Your ref: MP 10_0042 & MP06_0199
Our ref: 10/X001 & 06/X014

2 November 2010

**RE: ALDI WAREHOUSE PROJECT AND REVISED SUBDIVISION LAYOUT
SUBMISSION MP 10_0042**

Figure 8: Access Arrangements

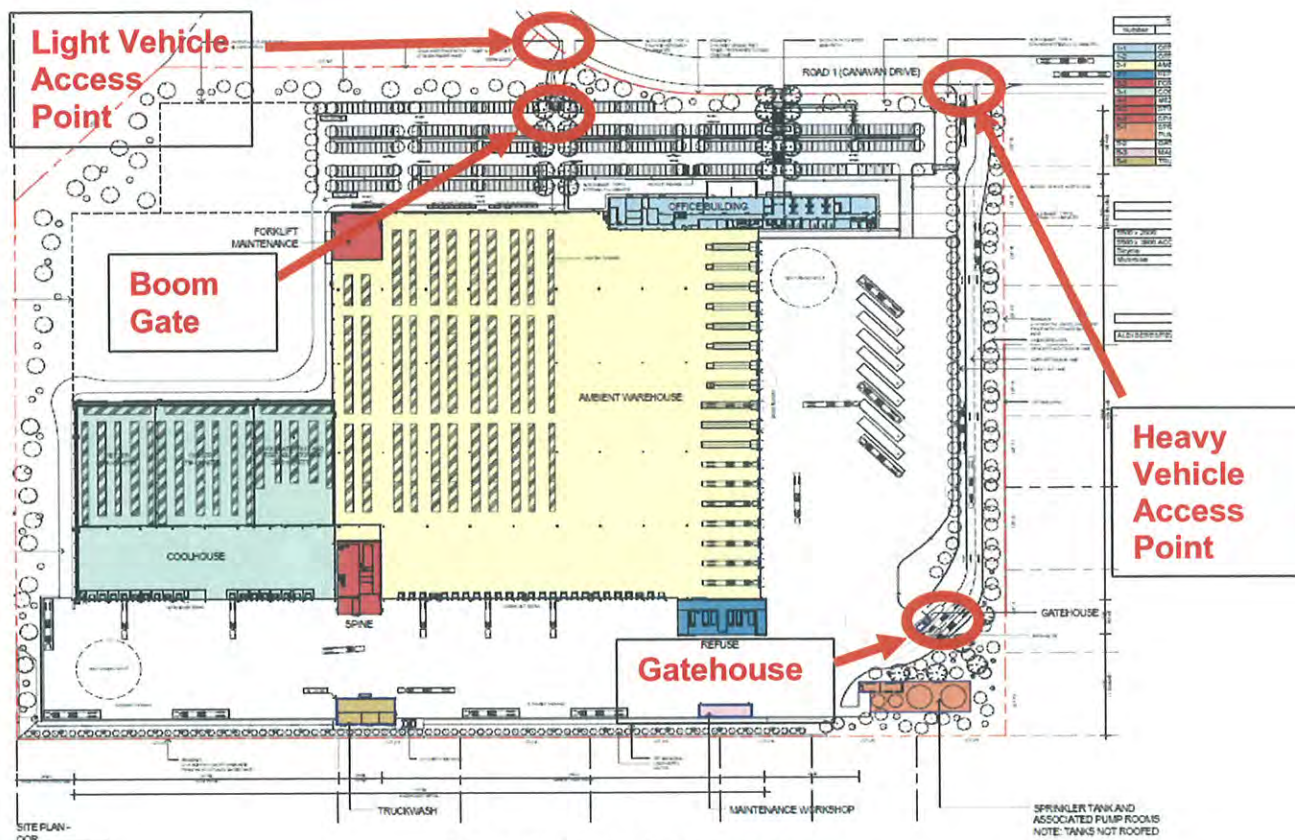
- The development is to be left in and right turn out only for trucks entering the site with dedicated acceleration and deceleration lanes in the adjoining proposed roadway entering the site.

- The queue lengths for traffic in front of the boom gates is to be investigated to ensure that queues don't overflow onto the roadway during the peak for both the truck entry and the standard vehicle entry

- Adequate turning areas and movements for the large vehicles' servicing the site is to be provided in accordance with AUSROADS design vehicles and turning path templates. Ensuring that the sweep path is totally contained within the road/driveway areas
